Project No. 610.032216.00001

**RE: 37 Archer Street, Chatswood
Response to Submissions Updated Project Description**

This report comprises an addendum to the 610.032216.00001-R01-v1.1- 20251021 report prepared by SLR Consulting to support a State Significant Development Application (SSDA) for a mixed-use building at 37 Archer Street, Chatswood. It provides additional information to describe amendments to the proposed design which have been implemented in response to feedback received from the State Design Review Panel (SDRP), the Department of Planning, Housing and Infrastructure (DPHI) and Willoughby City Council (WCC). Public exhibition of the application occurred between 20 June 2025 and 21 July 2025.

Figure 17 Wind Mitigation for the Development as outlined in the SSDA design – Elevated Communal Open Space (Level 8)

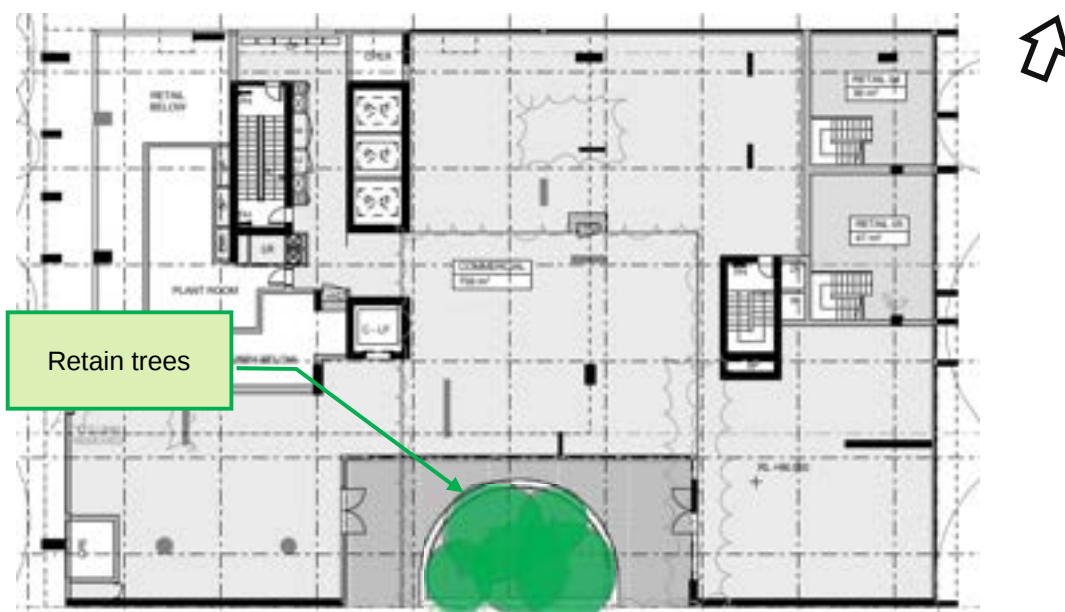
2) Detail the full heights and structural forms of the physical wind mitigation measures recommended by the wind assessment on the plans and update any references to building height accordingly.

The communal open space, previously located on Level 8, has now been relocated to Level 6. This modification slightly alters the local wind environment, as the lower position is less exposed to higher-level wind effects. Despite this adjustment in the updated design, the previously recommended wind mitigation measures remain applicable. Consistent with the earlier SSDA design, it is recommended that:

- Install glazed balustrades along the eastern and western edges of the Level 6 communal open space. These should be complemented by shading elements above the eastern seating areas and tall evergreen trees to improve wind protection and thermal comfort, ensuring compliance with the seating comfort criterion. (**Figure 1**).
- Wind speeds within the Level 6 communal open space, exceeded the seating comfort threshold. To address this, it is recommended to replace the proposed fence-type balustrade with a 2.5 m-high glazed balustrade to provide effective wind shielding (**Figure 1**).

Figure 18 Wind Mitigation for the Development – Rooftop

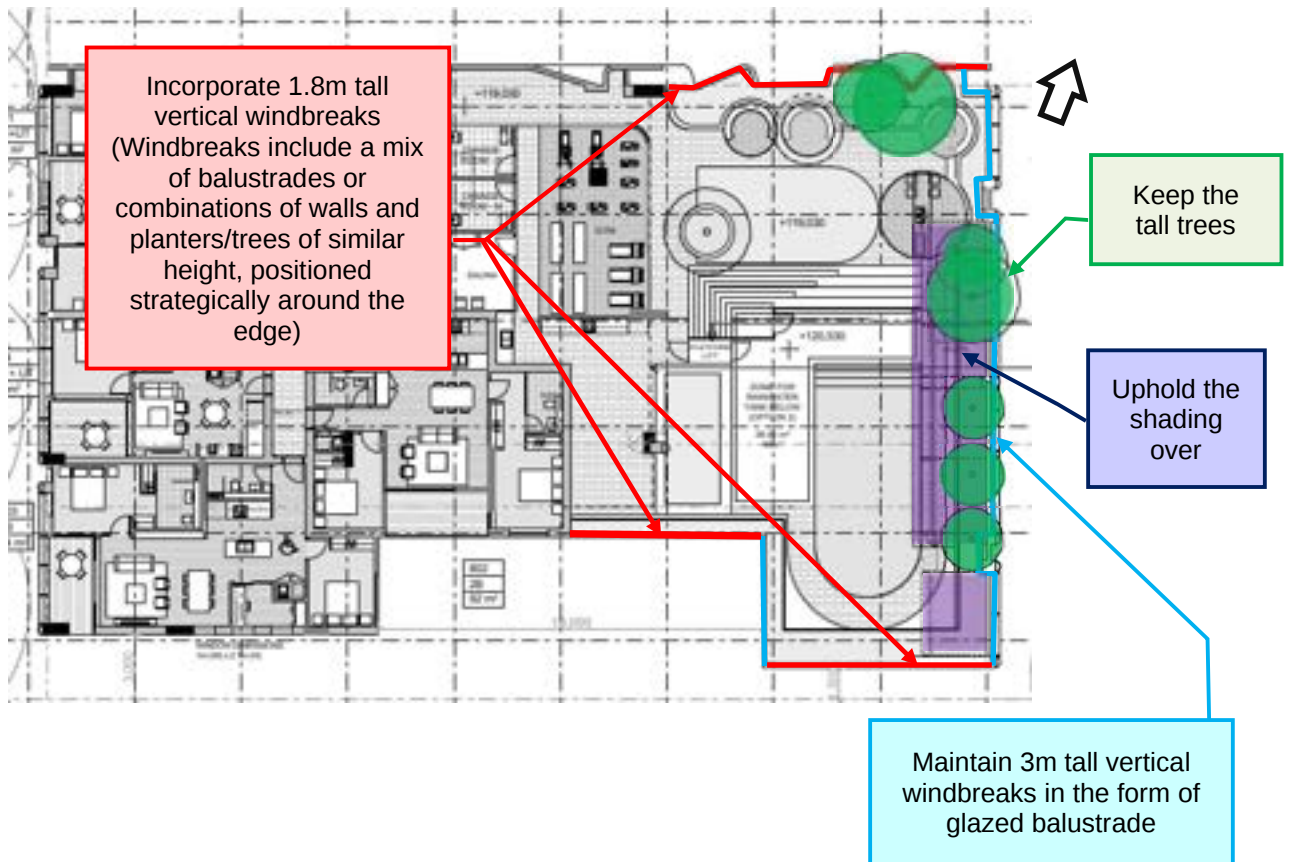
The current rooftop design has undergone minor changes compared to the previous design; therefore, the wind mitigation recommendations have been updated accordingly, as outlined below:

- The proposed glazed balustrades along the eastern and southern outer edges of the rooftop, will help achieve the required standing comfort criteria in this area.
- It is recommended to increase the height of the vertical windbreak along the western and northern edge of this area to at least 3m to achieve the required seating comfort criteria. Windbreaks can include a mix of balustrades or combinations of walls and planters/trees of similar height, positioned strategically around the edge (**Figure 2**)
